Harnett County Government Complex
307 Cornelius Harnett Boulevard
Lillington, NC 27546

RE: Existing Septic System Inspection HTE# 16-5-40059

**Site Plan Approval**  
 DISTRICT RA30 USE Det Garage  
 #BEDROOMS 1  
 Date 11/3/16  
 Zoning Administrator [Signature]  
 EIP Control Point

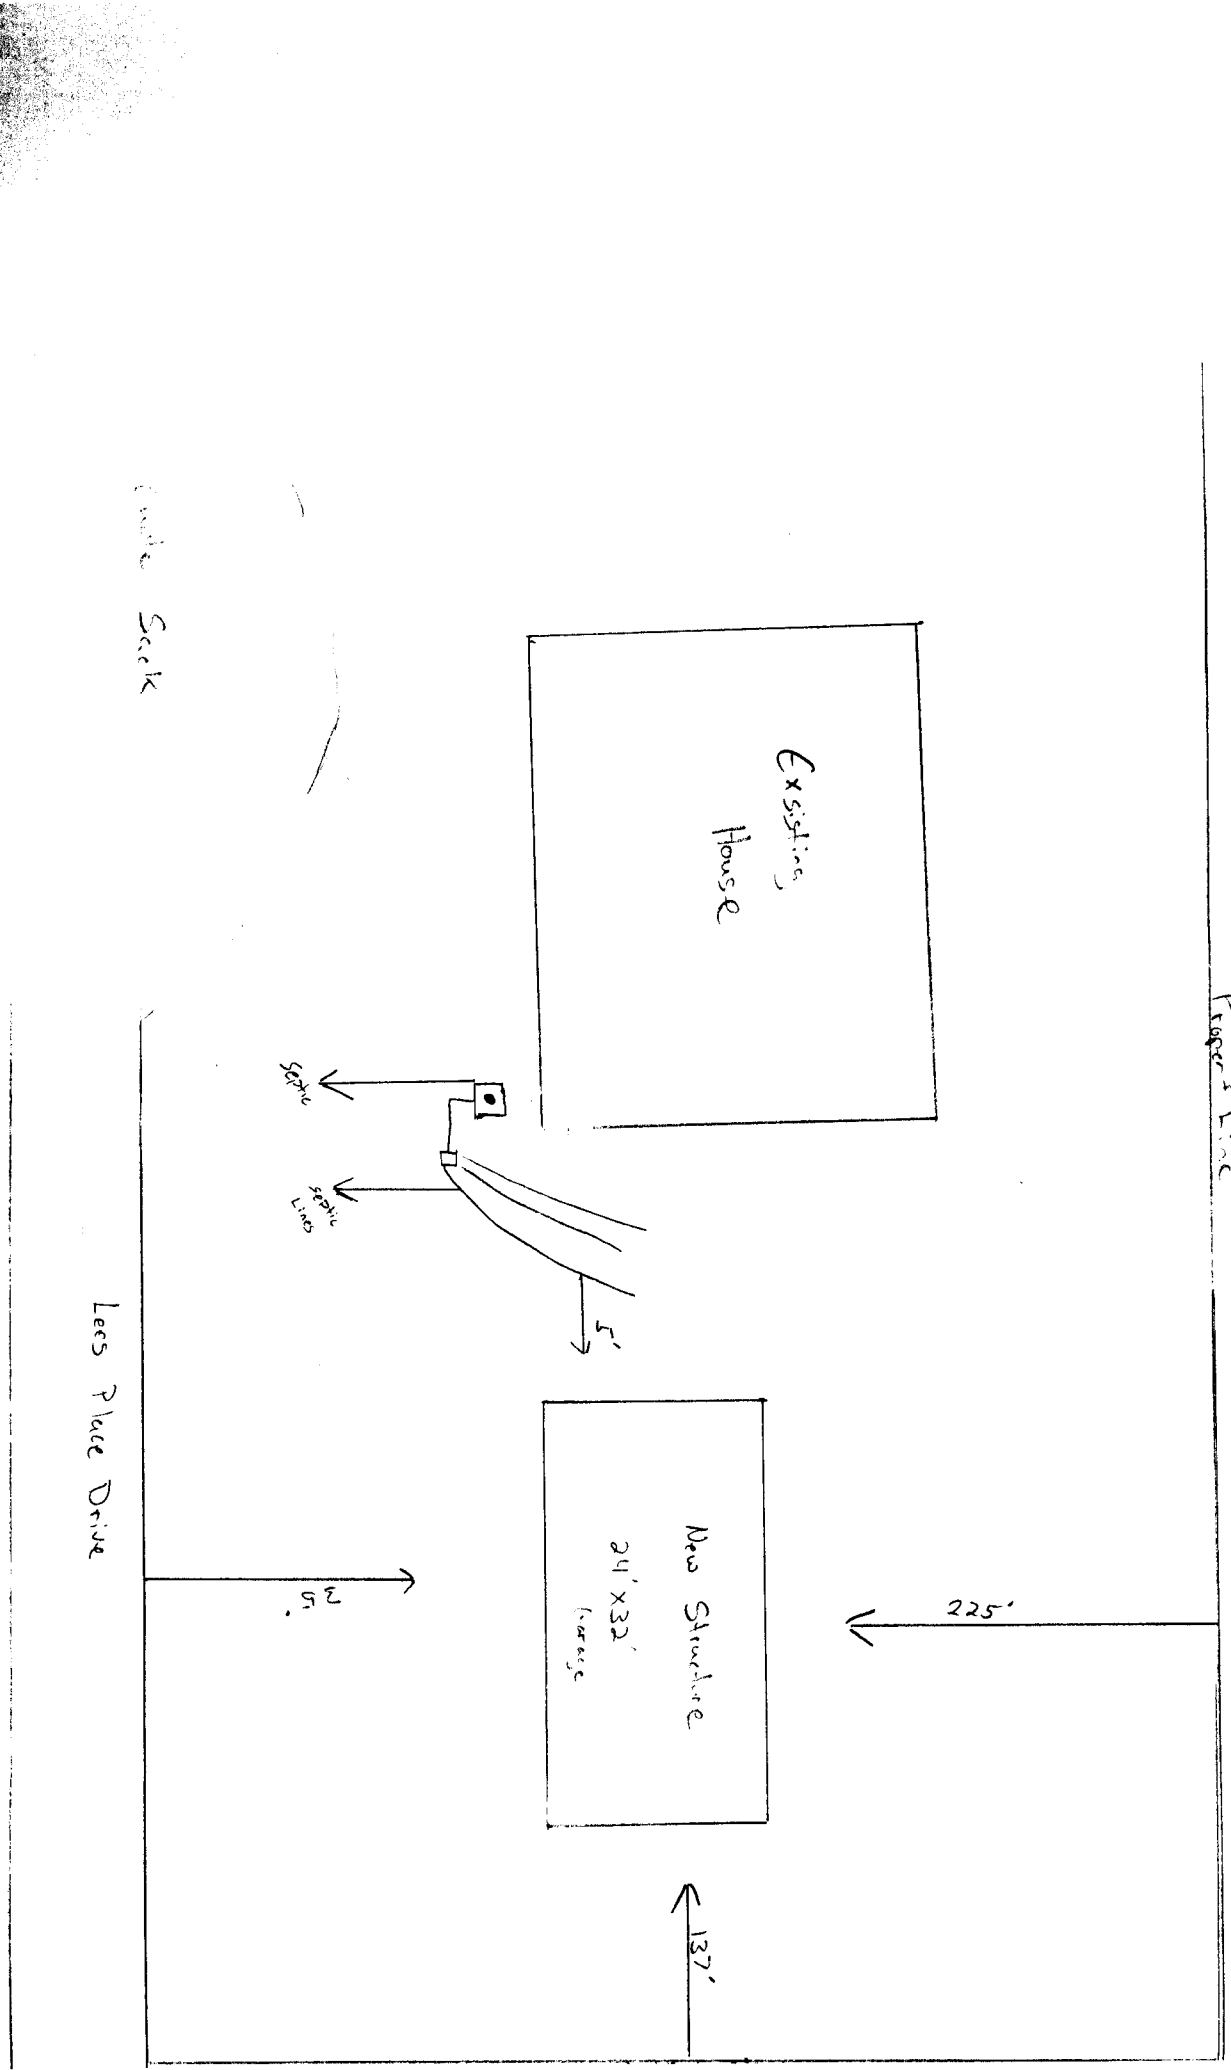
- 1. Uncover outlet lid on septic tank and break seal (**\$25.00 fee incurred**)
- 2. Have system pumped out
- 3. Replace sanitary T
- 4. Other – Flag Out Proposed Garage
